TOWN PLANNING & DEVELOPMENT ADVICE

17 September 2009
Ref: GS06010.15

**Part 3A Application (05-0129)
Noubin Projects Pty Ltd – The Lakes Estate
North Boambee Road, Coffs Harbour**

LAKES DVE, NTH BOAMBIE, COFFS HBR
Proposed Subdivision

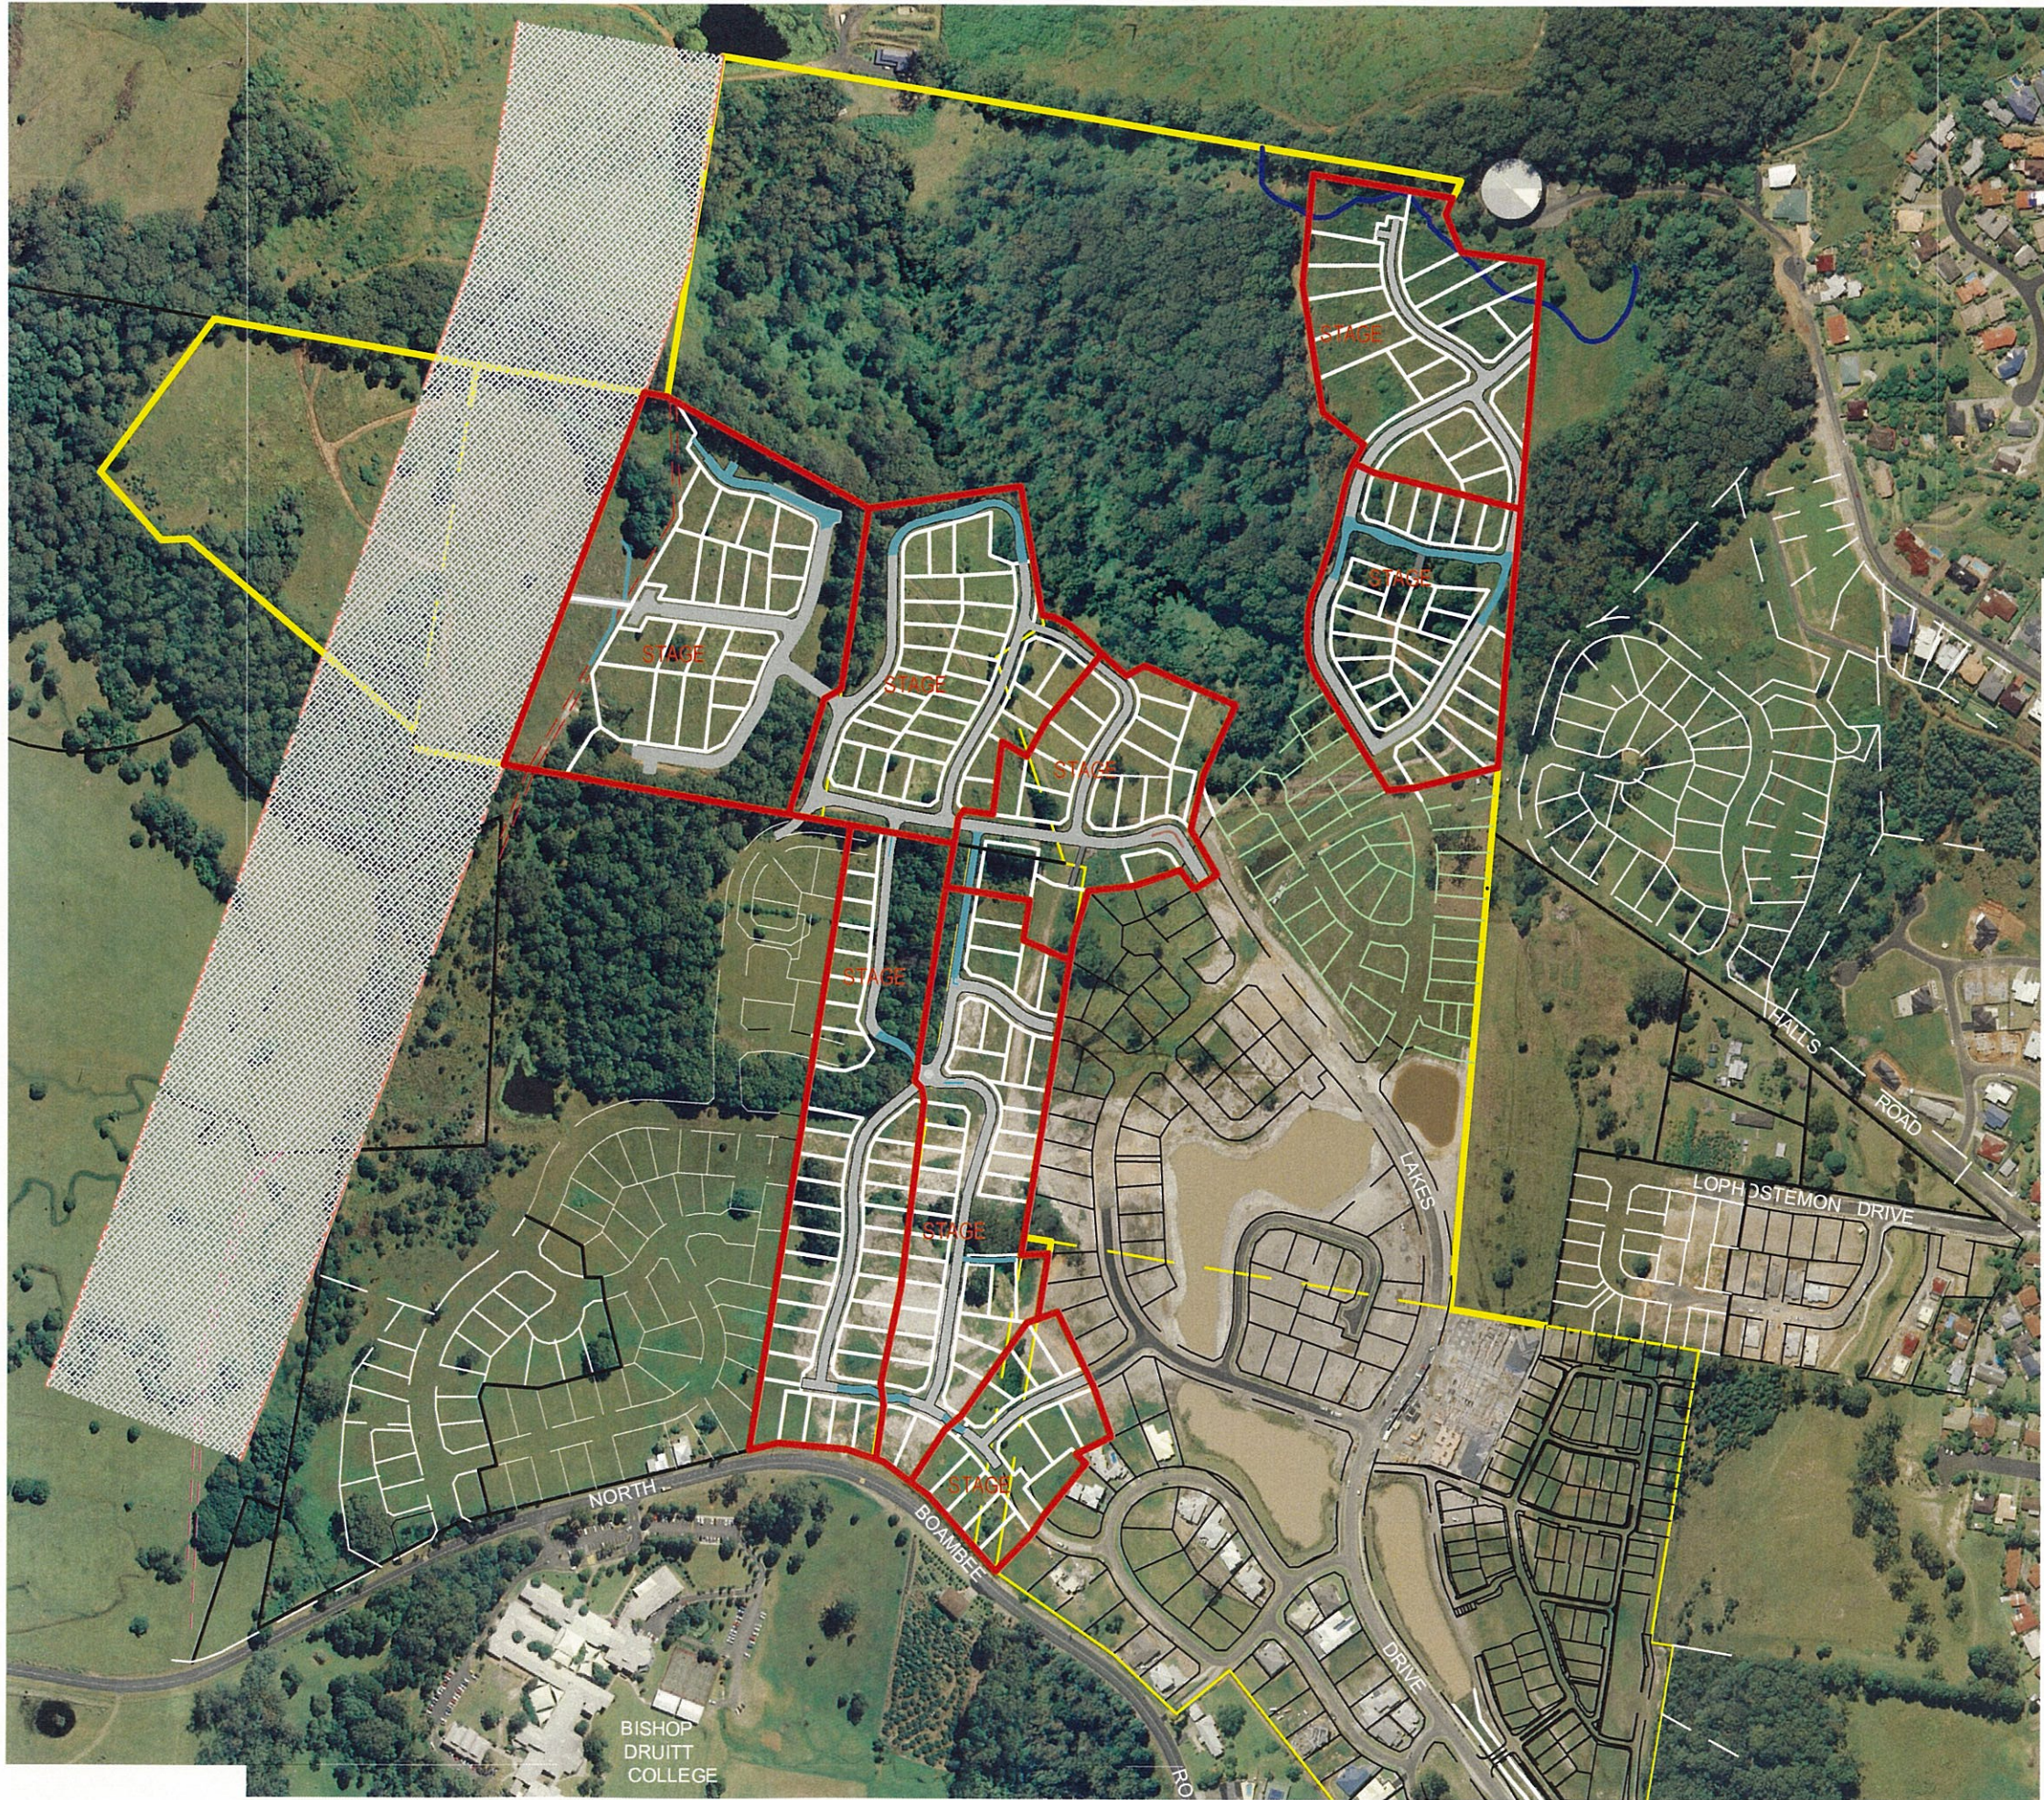
Our concern is the location of the access as shown in the subdivision layout in relation to site contours. The location shown will involve creating a road with grades of between 24 and 30% where an alternative location is available with grades of 16%.

It is also noted that the subdivision layout shows a 'Road No 1' as having only a half width carriageway, suggesting that part of the road width may be intended to be provided within my clients land and within a 7A Environmental Protection Zone. The plan should be amended to ensure that the full road width is contained wholly within the land that is the subject of the subdivision application. The subdivision cannot rely on adjoining land not held in the same ownership to facilitate road access.

Attached is a plan showing the layout as included in the application that is on exhibition and a plan showing an alternative layout that is more responsive to site contours. It is considered to be a better outcome if the subdivision layout currently on exhibition is amended as shown in the enclosed plan. Your inclusion of an appropriate condition to require the suggested amendment be incorporated would be appreciated if consent is to be granted.
